From: [REDACTED]
To: [REDACTED]
Subject: 12 The Baulks, Sawston, Cambridge. CB22 3NP - Non Material Amendment Application
Date: 07 March 2024 17:08:25
Attachments: [12 the Baulks NMA application form.pdf](#)
[12 The Baulks NMA drawings.pdf](#)

Planning Permission was granted for the proposed single storey extension at 12 The Baulks, Sawston under Planning Permission reference number 23/02272/HFUL dated 23 August 2023.

912/05^A 1:100 @ A3 MAY 2023

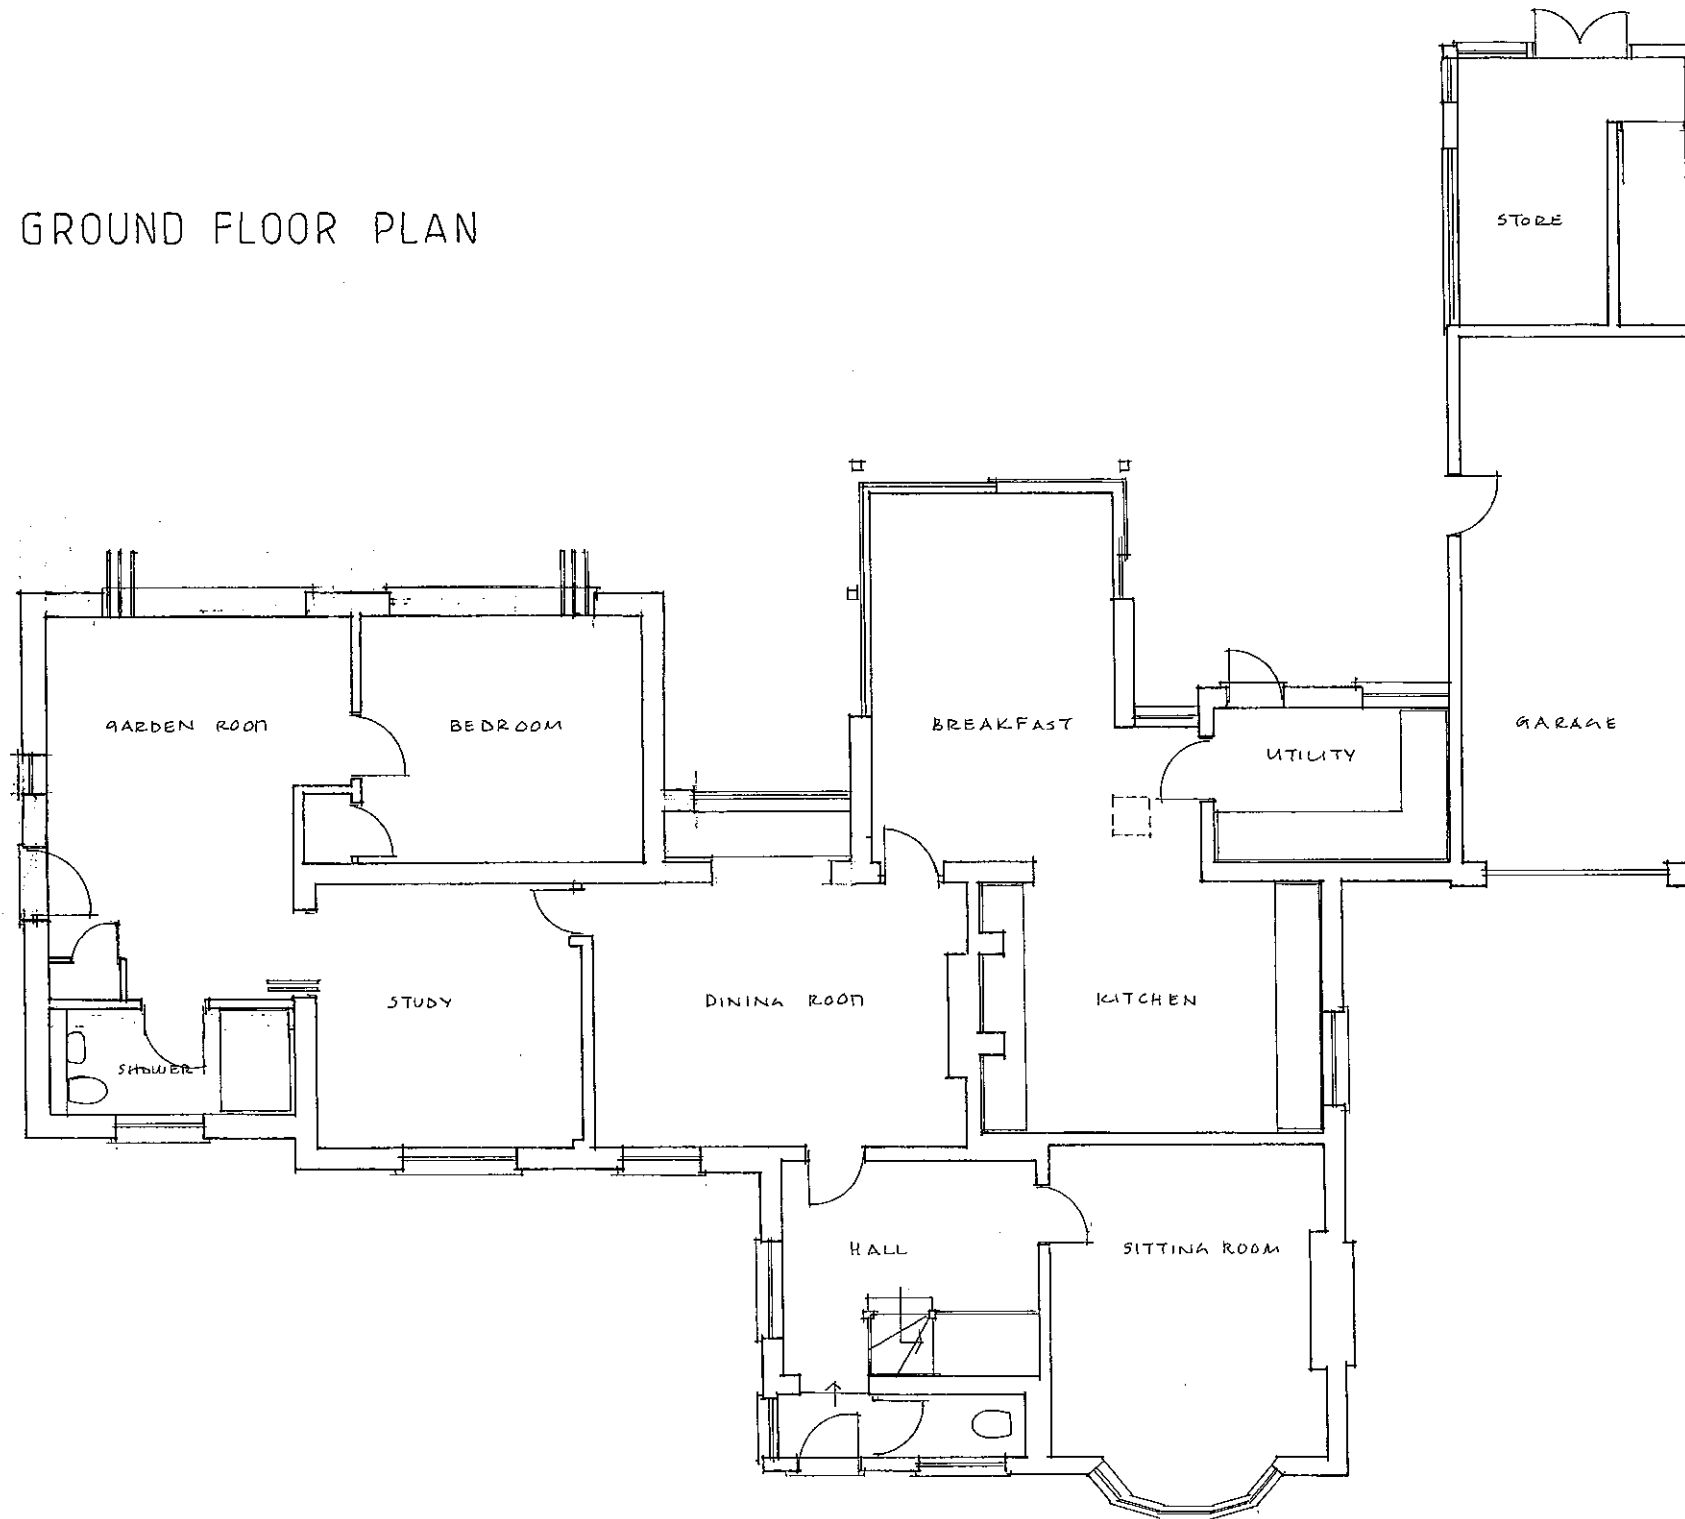
The applicants would like to make some modest alterations to the approved design, including the reduction in width of the doors in the garden room and bedroom. Reduction in the width of the Dining room bay window and the inclusion of a cupboard within the garden room.

- A copy of the Application form.
- A copy of revised drawing numbers 912/05A, 07A & 09A.
